From: Carmichael Ian <Ian.Carmichael@thamesvalley.pnn.police.uk>
Sent: Monday, December 30, 2019 10:49 AM
To: Linda Griffiths <Linda.Griffiths@Cherwell-DC.gov.uk>
Cc: Planning <Planning@Cherwell-DC.gov.uk>
Subject: Planning ref: 19/01037/REM (AMENDMENTS). OS Parcels 6741 and 5426 West of Cricket Field and North of Wykham Lane Bodicote.

Planning ref: 19/01037/REM (AMENDMENTS). OS Parcels 6741 and 5426 West of Cricket Field and North of Wykham Lane Bodicote.

Drawing Title
Enclosures Details 1 of 2

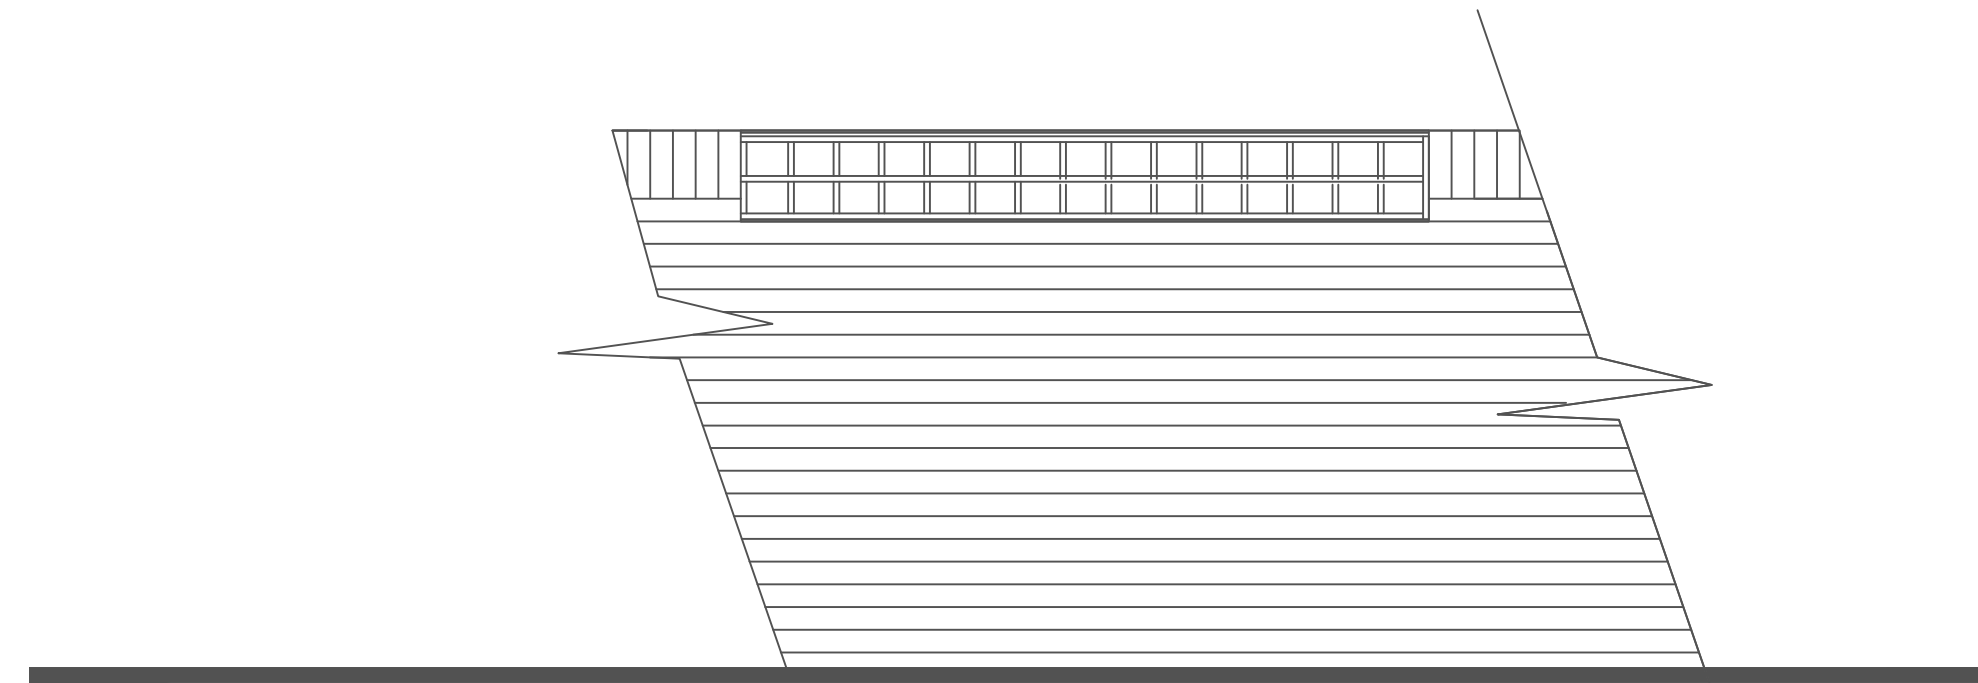
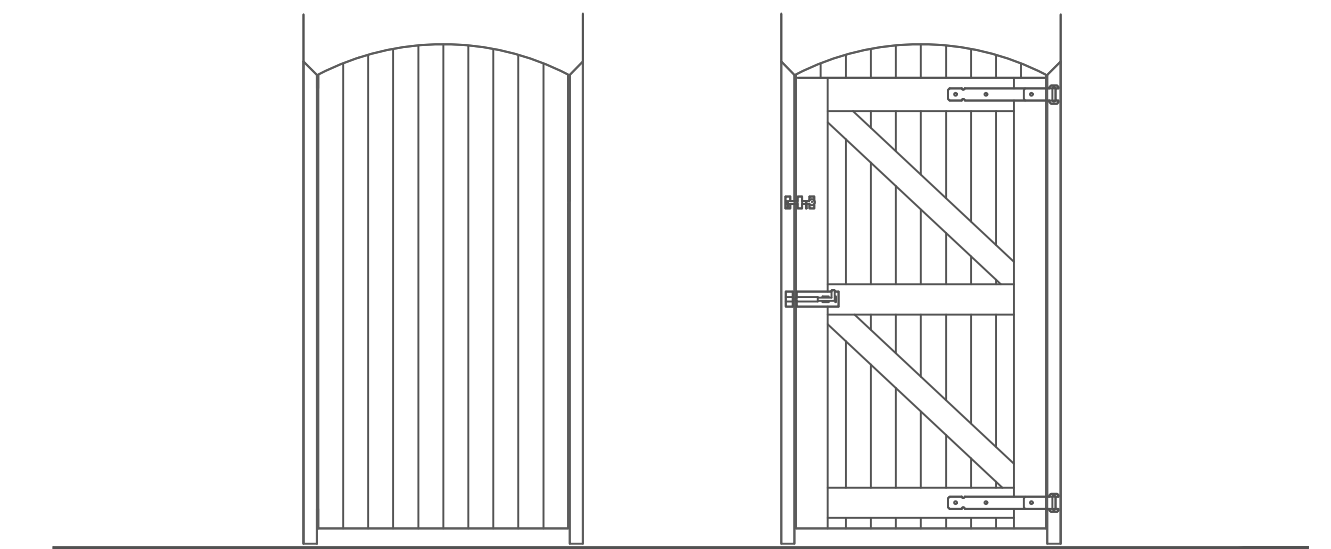
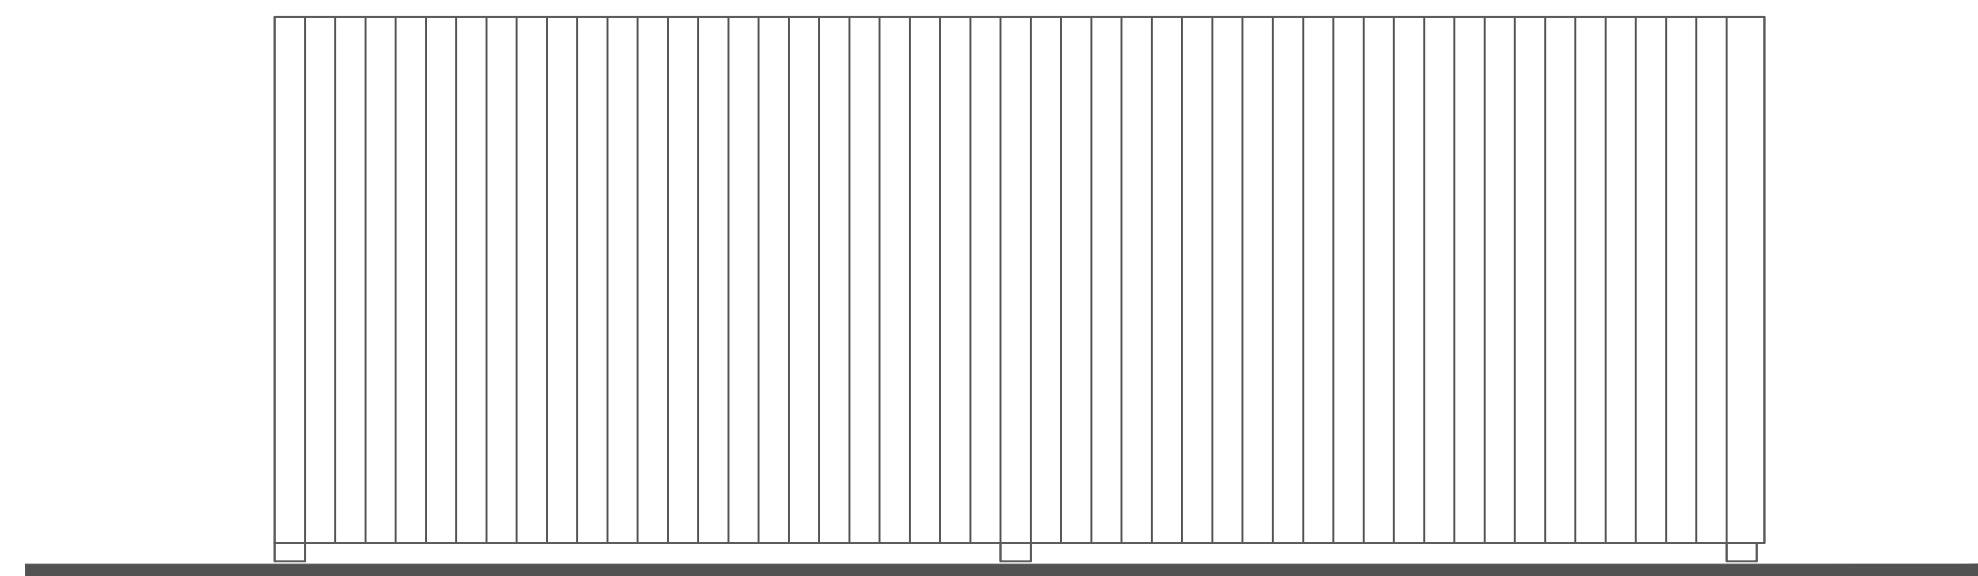
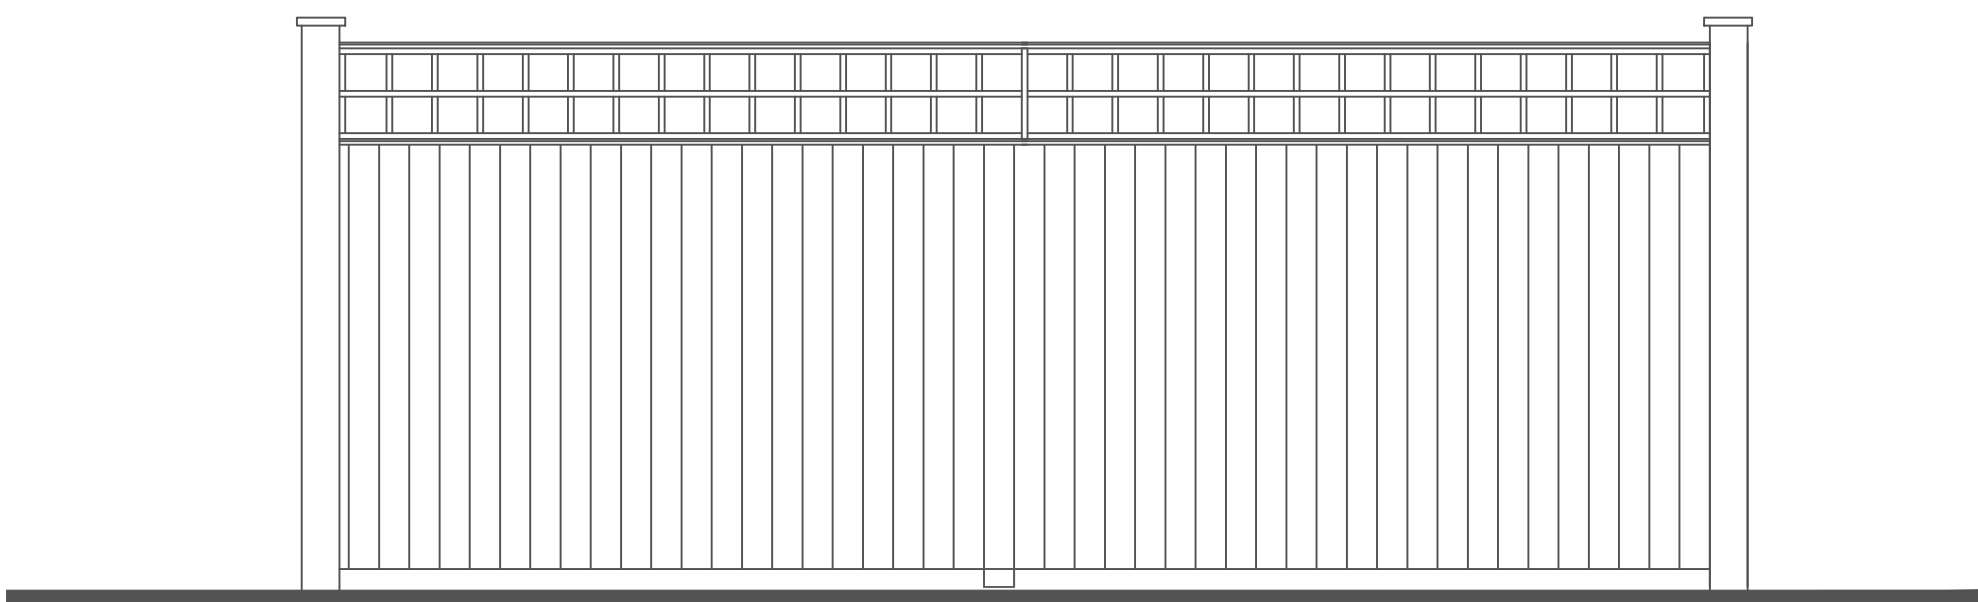
- Where boundary treatments of private rear gardens abut public or semi-private space they should incorporate features that make them difficult to climb; trellis on fences, angled or rounded copings on walls etc. All access gates to rear gardens (including communal ones) should be; robust, of the same height as boundary treatments, self-closing, have anti-lift hinges and be key operated from both sides. Also, some gates to rear gardens are not provided as close to the front building line as possible, which creates problematic recesses. I would like to see them brought forward wherever possible. And, I note that the DAS states that 'Hit and miss' fencing will be used to provide oversight of parking to the rear of properties. However, the Enclosure Plan shows no such fencing. The proposed visually permeable treatment should be used where possible and appropriate.
